APPEAL STATEMENT

Planning Inspectorate Reference:	APP/T2350/W/17/3178692
LPA Application Reference:	3/2017/0192
LPA Officer:	Stephen Kilmartin

Full planning consent for the change of use from former agricultural building to one dwelling

Countess Hey, Elmridge Lane, Chipping PR3 2NY

south elevation

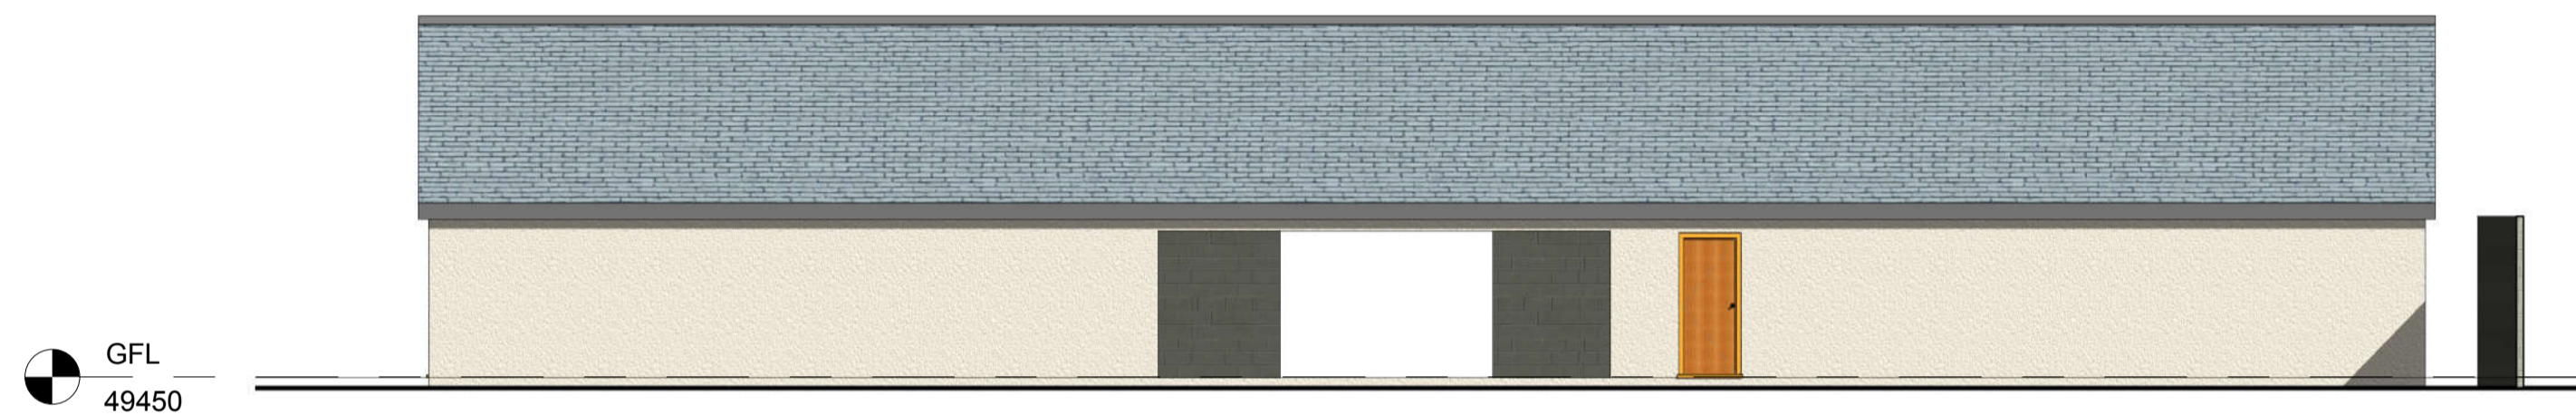
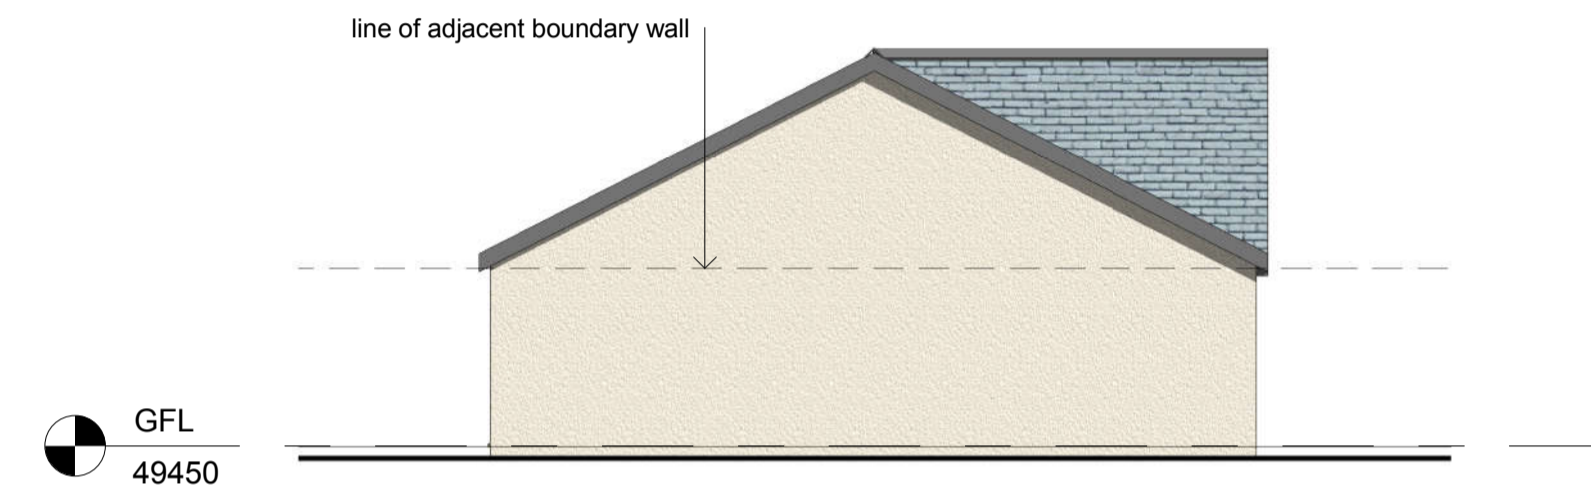
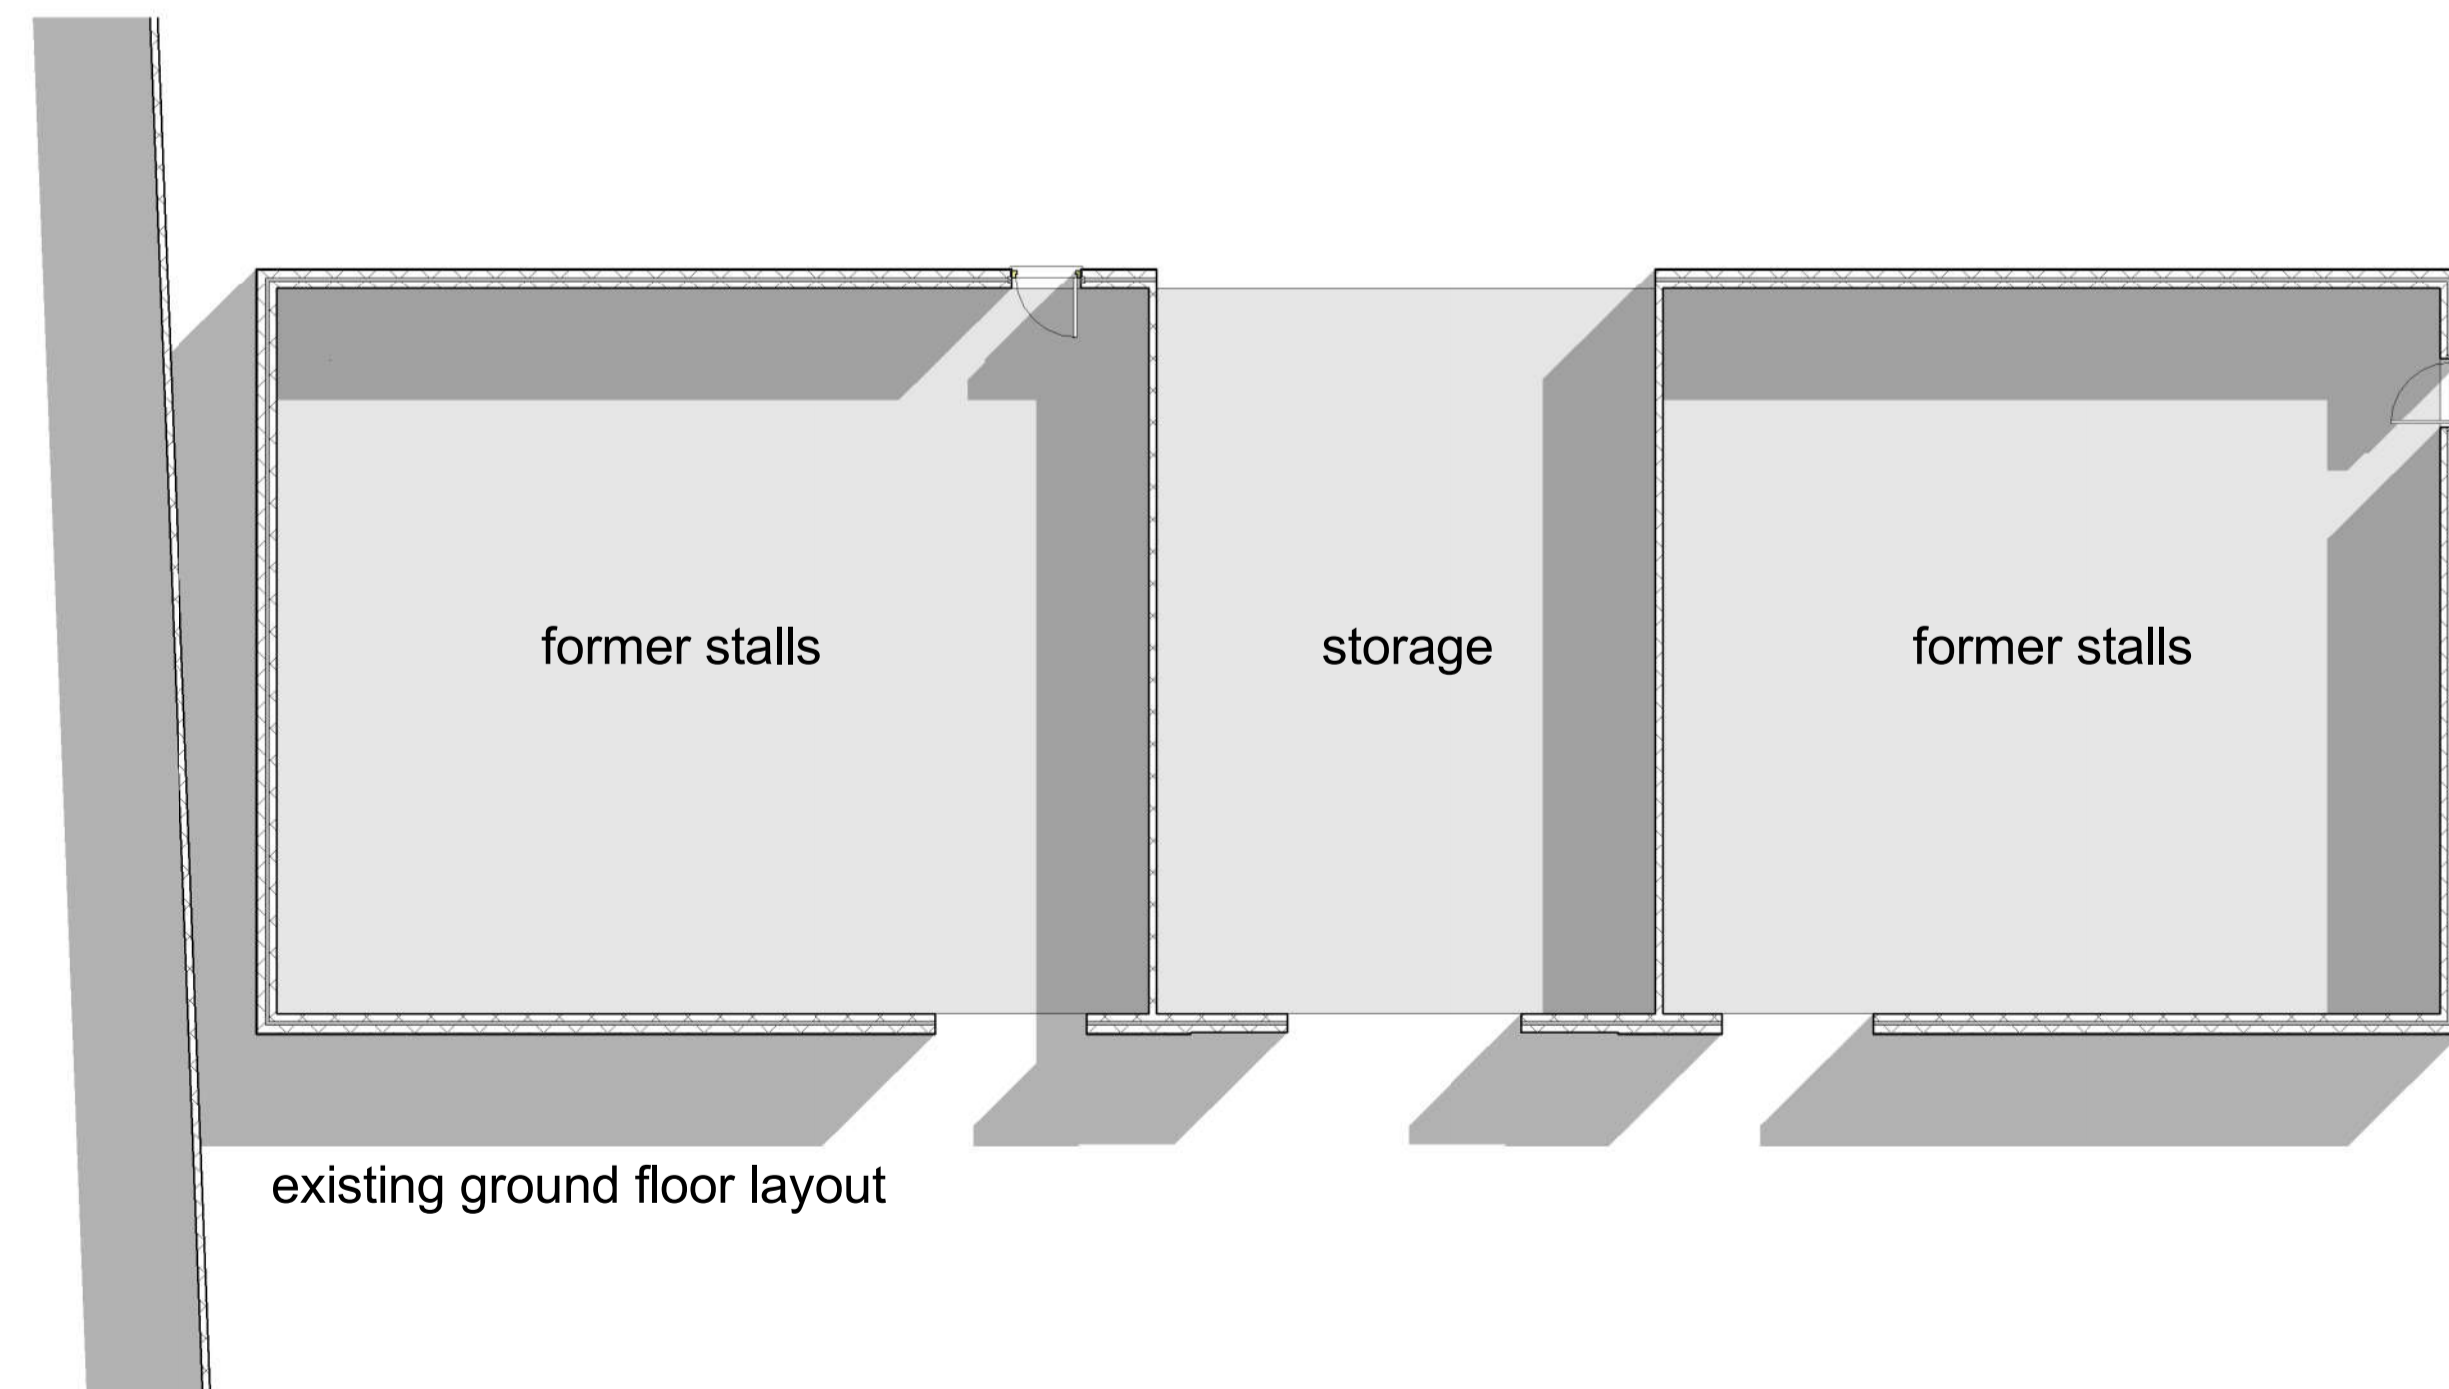
7.1 The existing building is a disused agricultural storage and livestock building of a predominantly blockwork construction with pitched roof and central gable feature. The building benefits from three openings on the southern elevation One of which providing access to the central storage area (centrally located) with the remaining two providing access to the 'former stalls', the overall arrangement of this elevations is largely symmetrical in nature. The north elevation benefits from two openings, the central of which once again serves the central storage area and the remaining opening providing access to the western most stall. The east elevation accommodated a domestic-sized door with the west elevation being devoid of any openings.
